AMENDMENT RECORD SHEET - LIVE APPLICATION

BLANNING AMENDMENT

Application No. H23/1061/02

EXTENSION & ALTERATIONS.

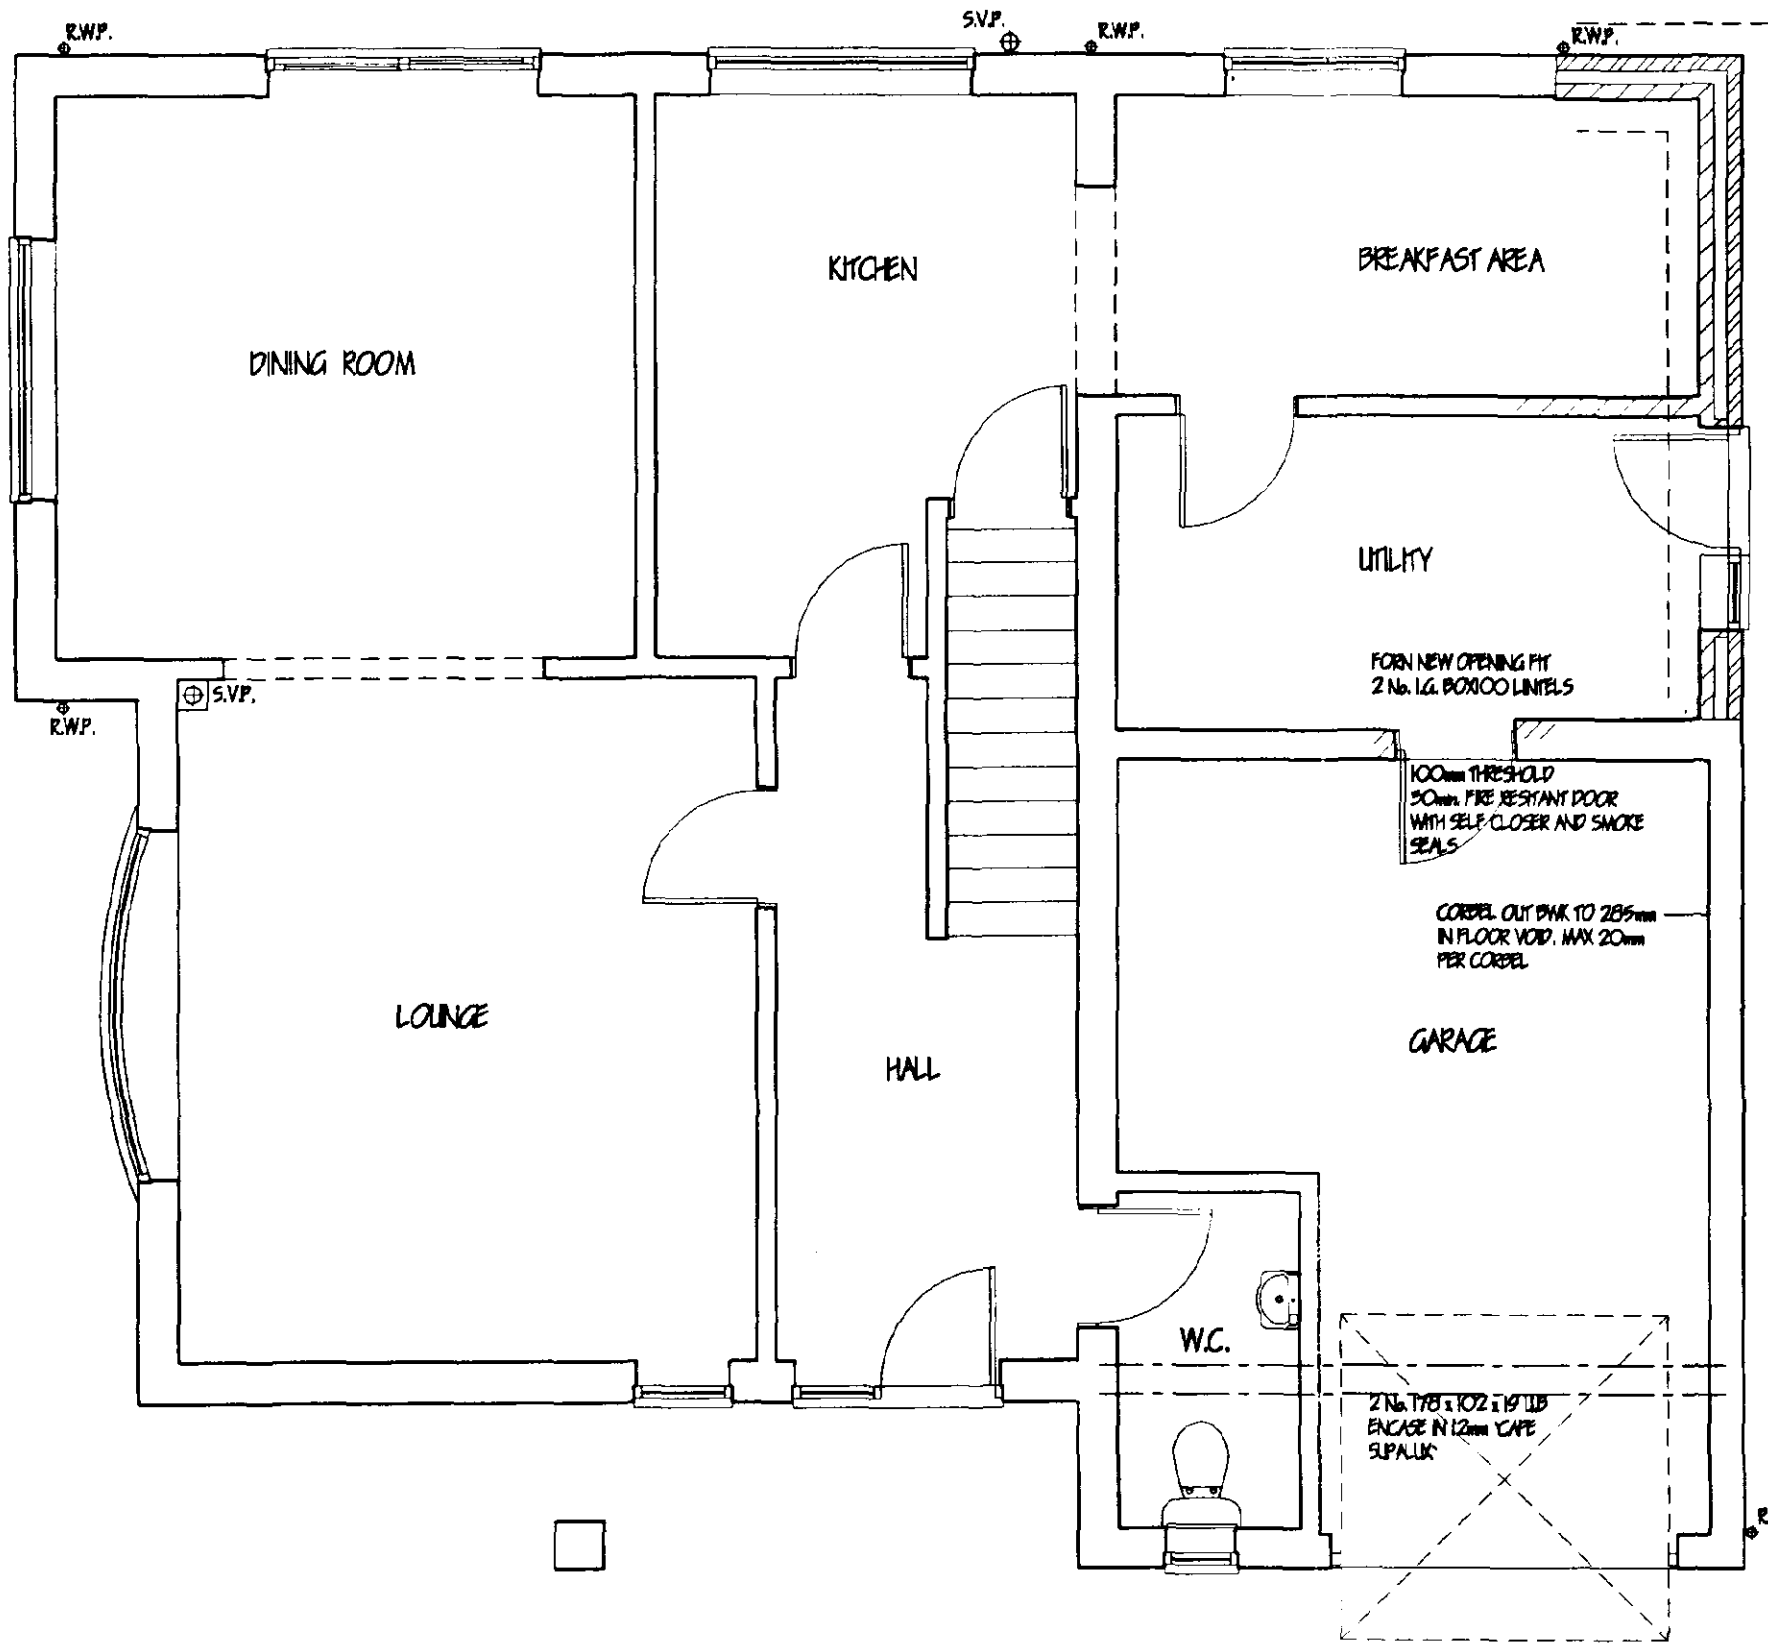
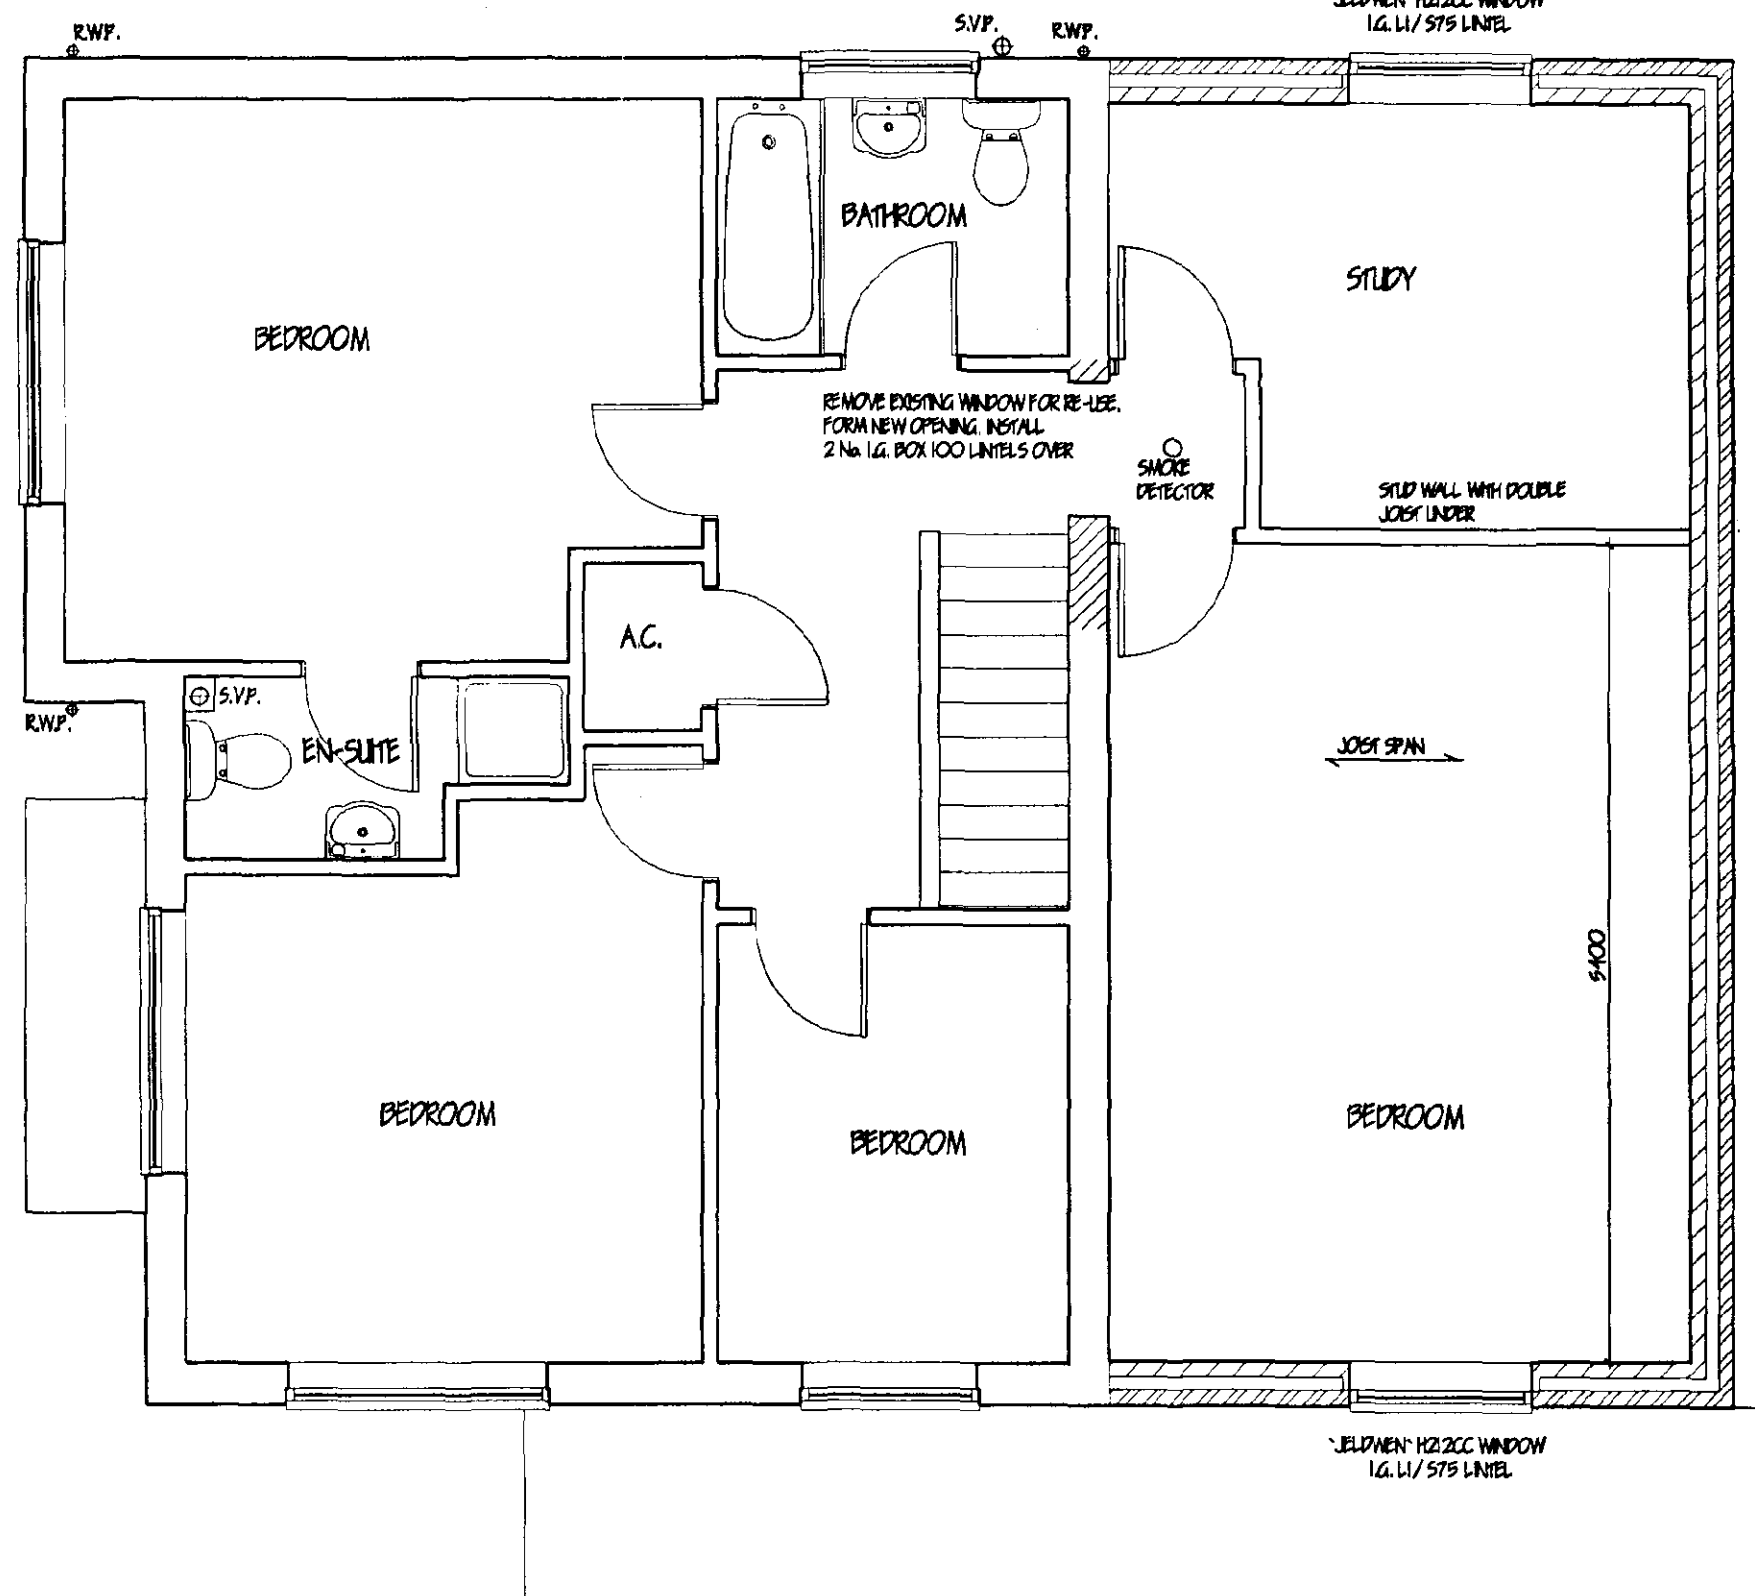
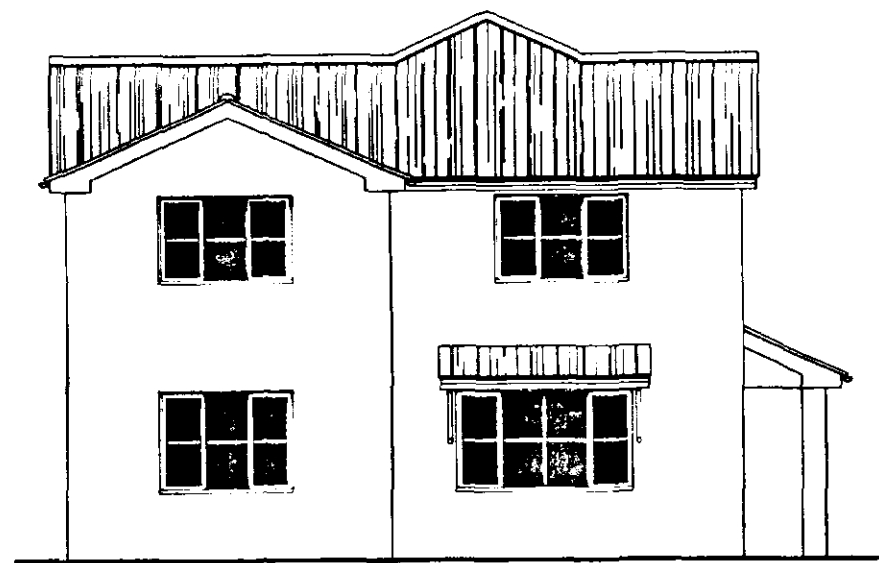
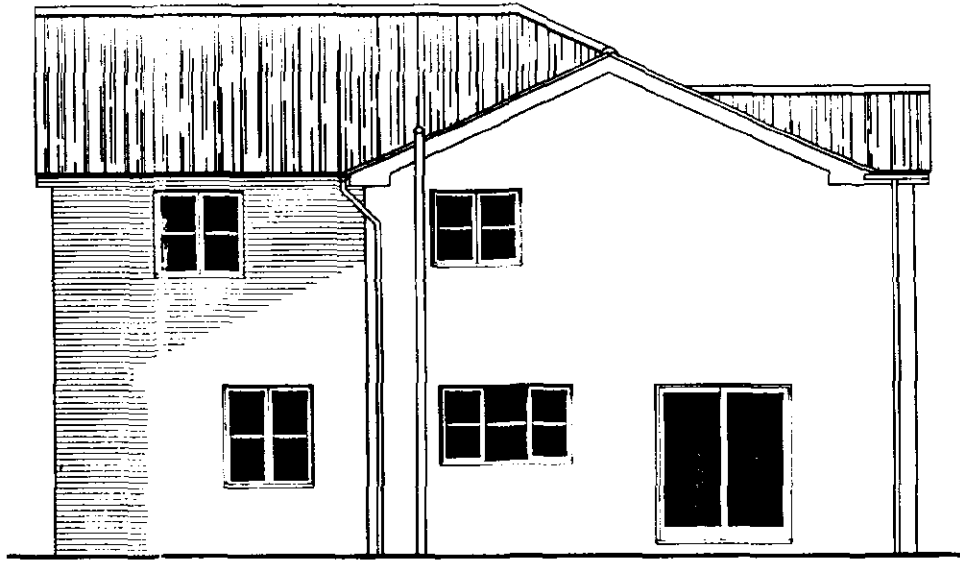
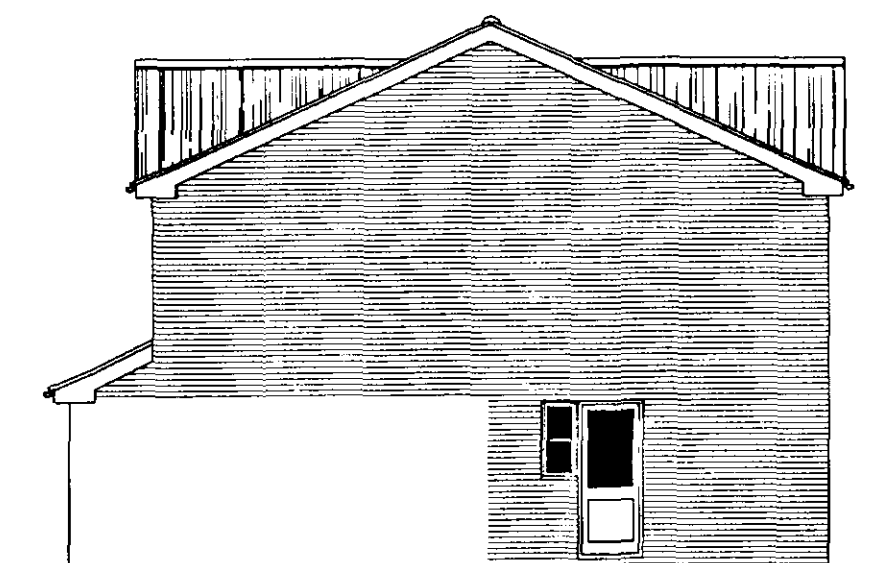
WINDOW REMOVED FROM STUDY.

Window removed from study
